From: Martyn White <Martyn.White@arun.gov.uk>
Sent: 08 October 2021 13:56
To: Planning.Responses <Planning.Responses@arun.gov.uk>
Subject: BN/111/21/L

BN/111/21/L

Shelley House Church Lane Eastergate PO20 3UR

Listed building consent for single storey rear extension and associated alterations (This application may affect the character and appearance of the Eastergate Square Conservation Area)

PROPOSED GROUND FLOOR PLAN
1:100

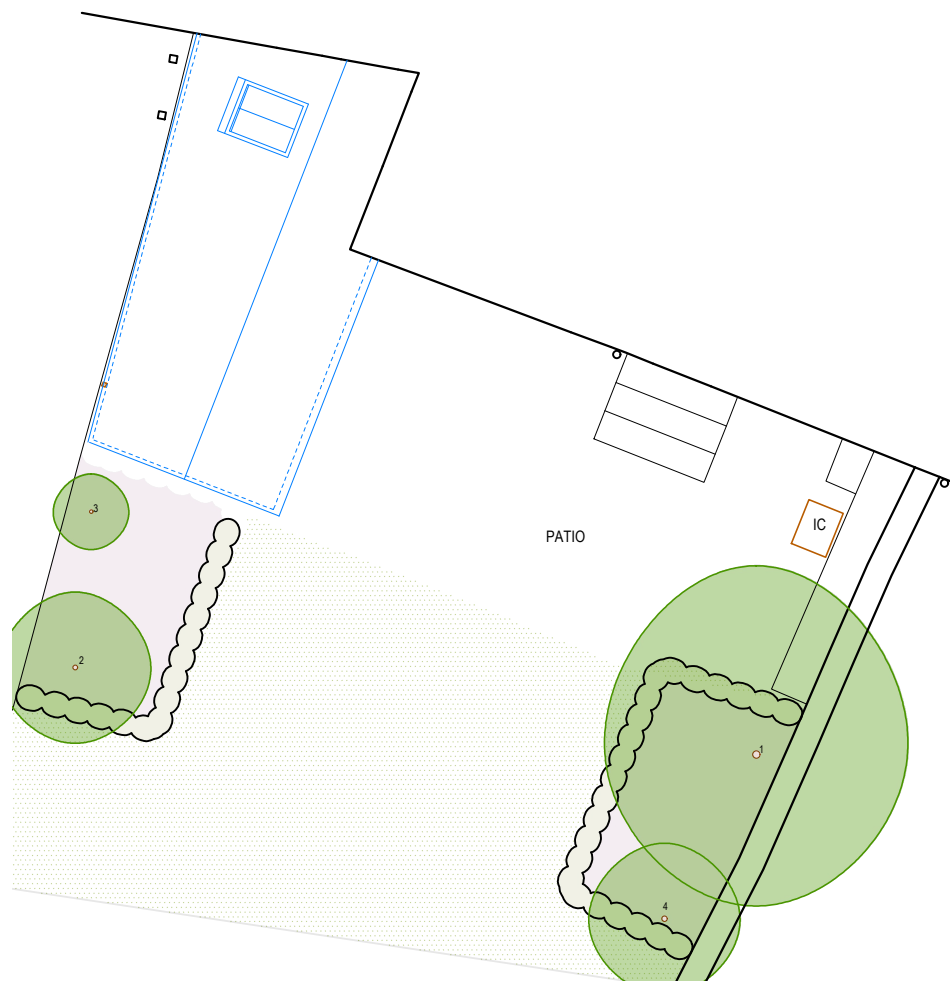
The heritage statement identifies that the existing kitchen window will be removed, and the opening enlarged to form a doorway leading from the kitchen into the new extension. Whilst this will naturally lead to a loss of some historic fabric, the amount is not considered to be of concern. The applicant could also retain any useful material for any future repairs to the building or boundary walling.

The existing external door and window from the utility room will be blocked in. This part of the listed building appears to be a much later addition and of no significance. In fact, the proposed extension will screen this part of the building from view, which is positive.

PROPOSED SOUTH ELEVATION
(VIEW FROM THE BACK GARDEN)
1:100

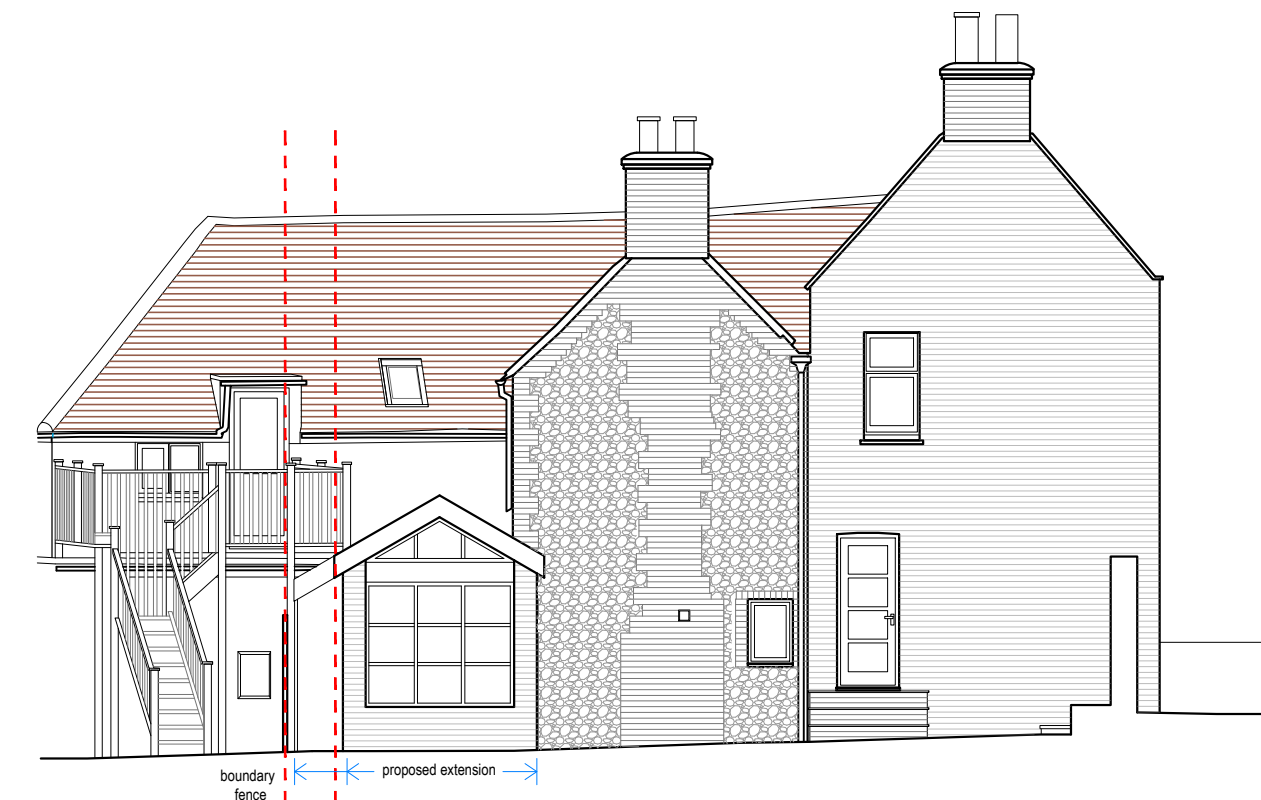
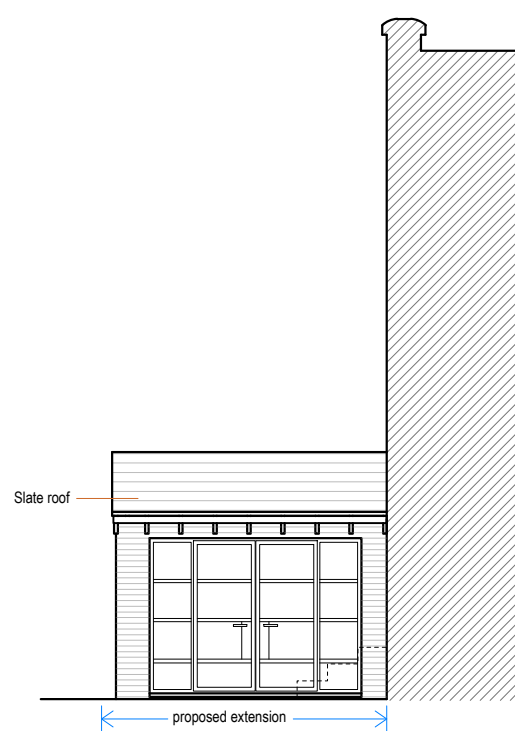
The proposed single storey extension is simple in appearance and reflects the simple elevation of the listed building it is to be attached to. Whilst the gable (south) elevation with apex glazing is a little fussy, especially along with the bargeboard, I am of the opinion that, on balance, it would not cause harm to the significance of the building. Further, it would not be clearly viewed from the nearby roads due to the existing boundary walling and planting. The success of the scheme will therefore depend upon the materials used and the quality of the windows and doors. Details of the windows/doors should be provided for by way of condition. This should include the design, glazing, specification, method of opening and finish, in the form of drawings and sections of an appropriate scale.
